Ute Pass Mini Storage, PPR-18-028

Please accept the following comments from El Paso County Public Health (EPCPH) for the project referenced above:

1 SITE PLAN
SCALE: 1"=30'-0"

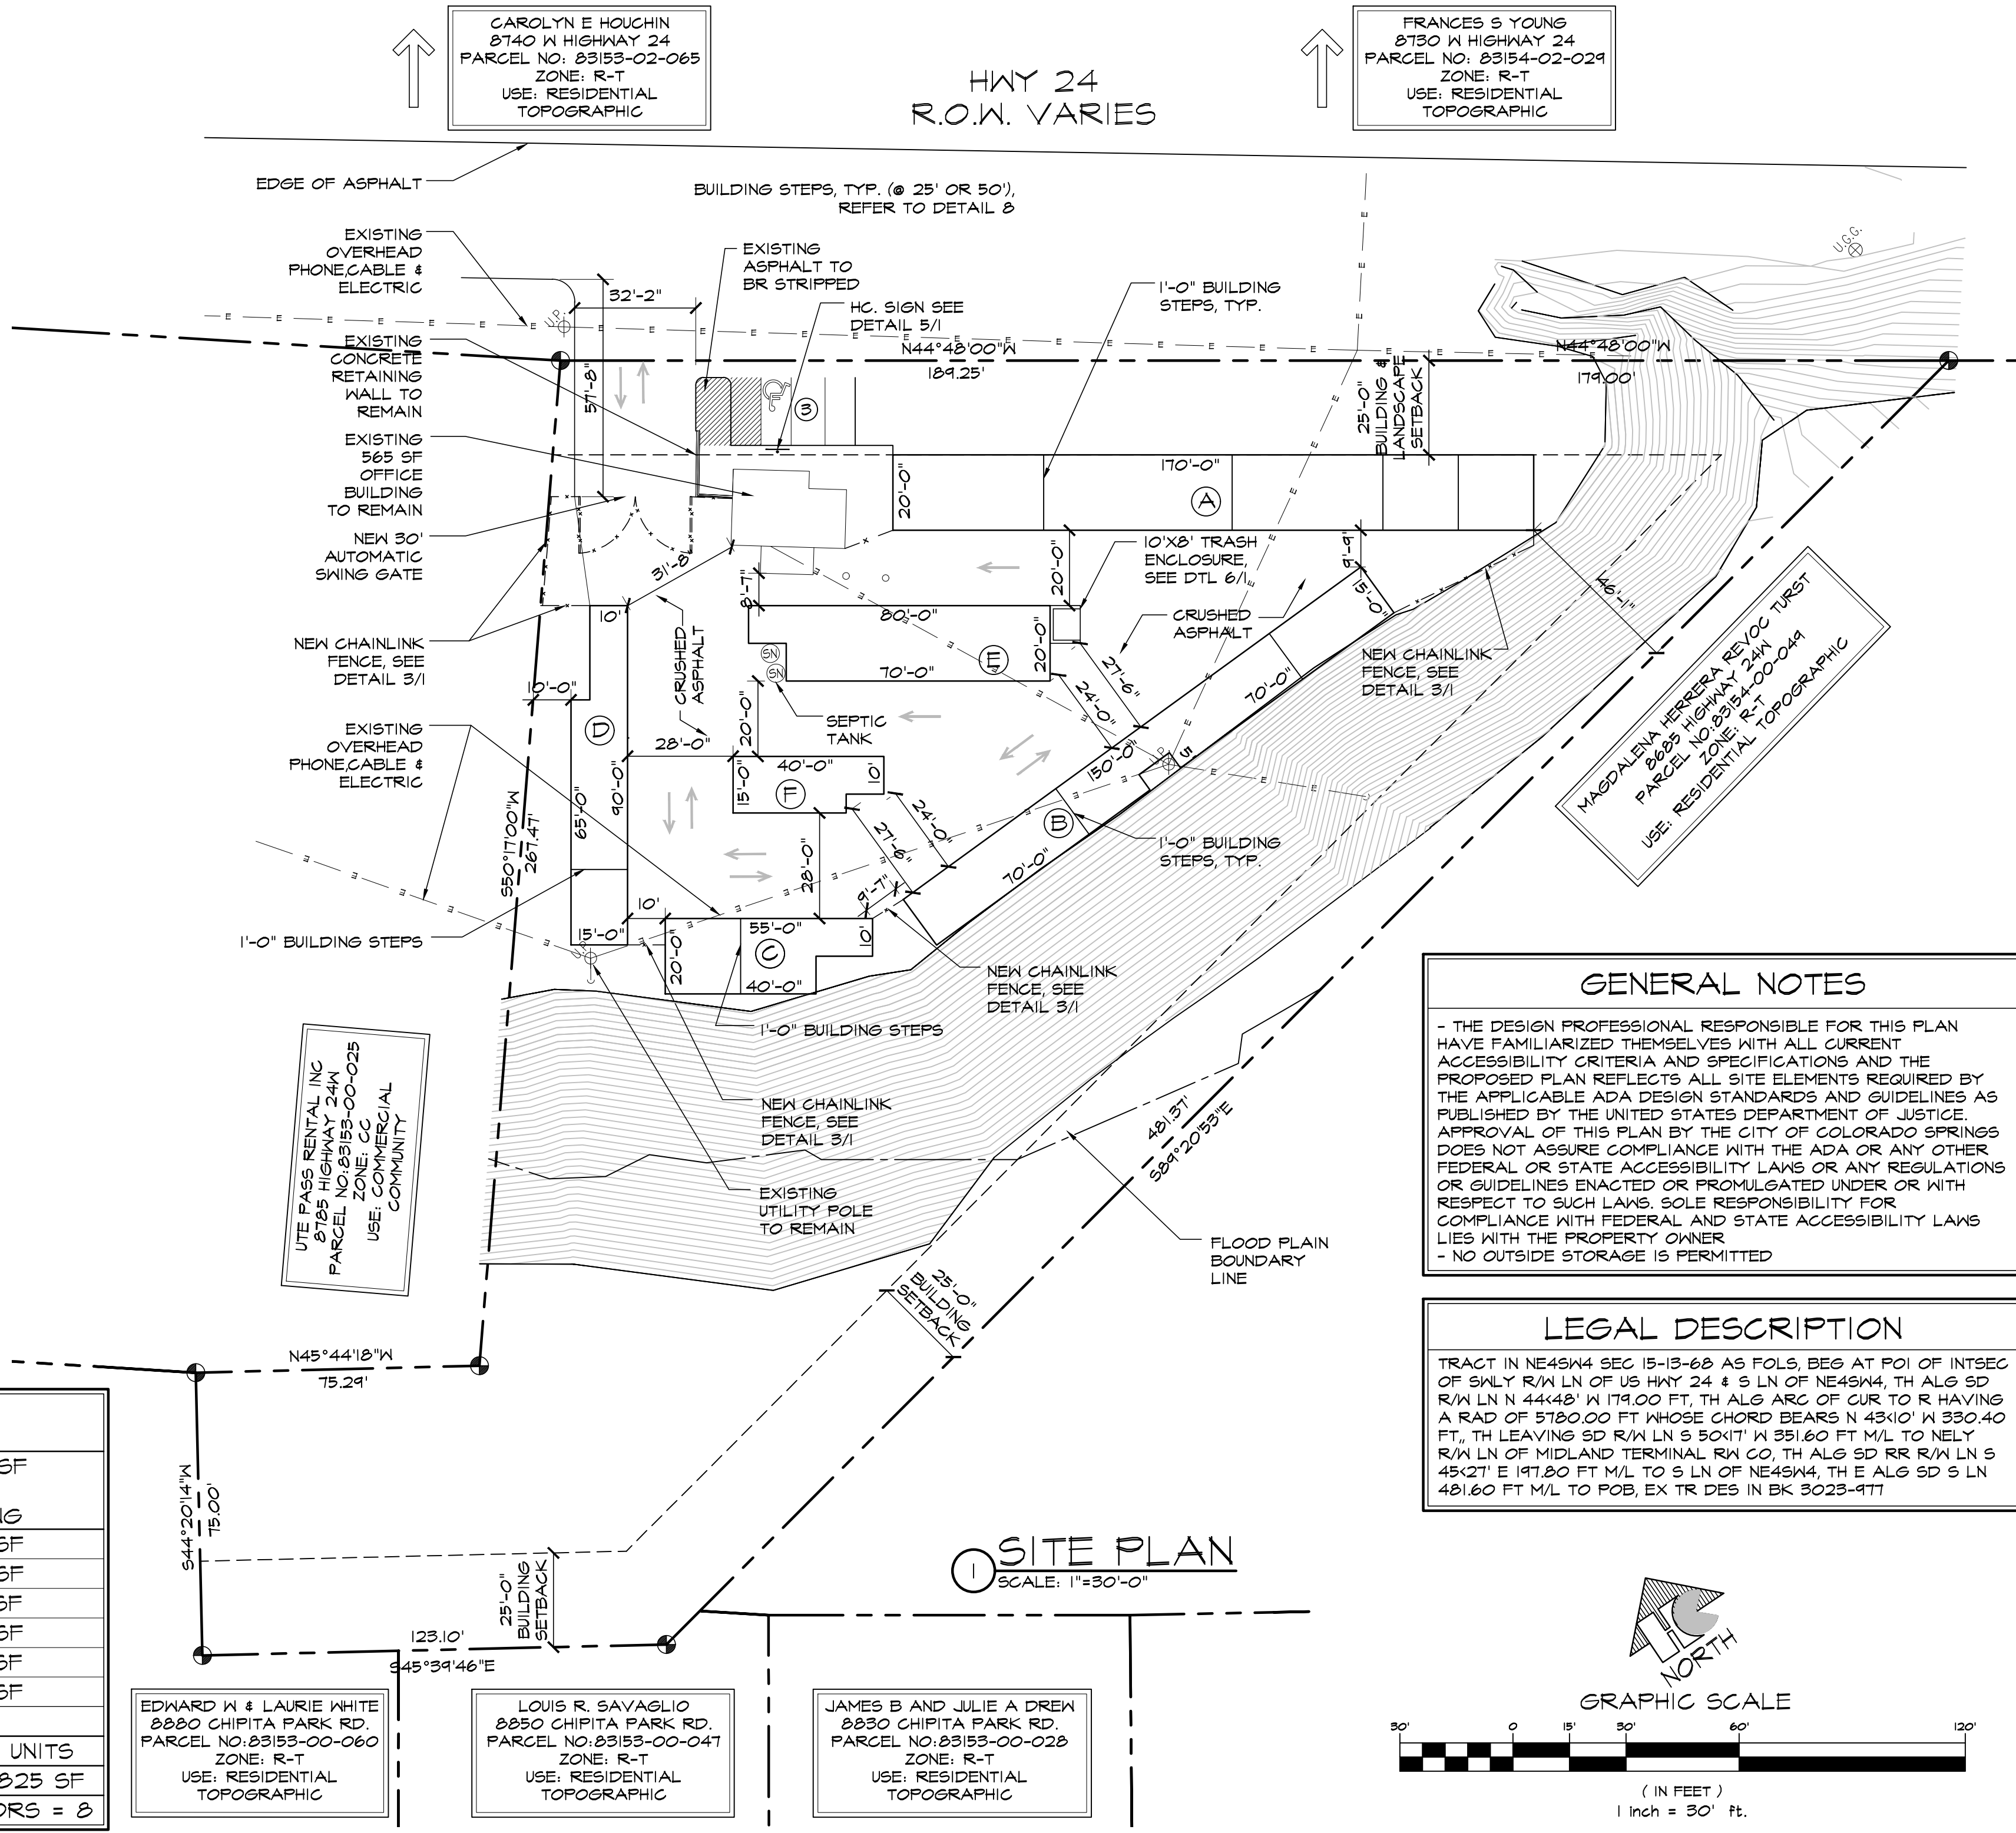
- The site development plan showed the location of a septic tank on the property, but not the soil treatment area (STA). The STA must be located and protected from compaction associated with construction traffic, building construction and parking. Locating the STA, which is likely a deep seepage pit/drywell is essential for safety reasons as well as for public health reasons.
- El Paso County Public Health does not have a record of the OWTS installed on the property; however, EPCPH did not require records or permits until 1966, and the existing structure was built in 1955.
- If earthmoving activities for the project exceed 1 acre, then go to EPCPH for a Construction Activity Permit:
<https://www.elpasocountyhealth.org/service/air-quality/construction-activity-application>
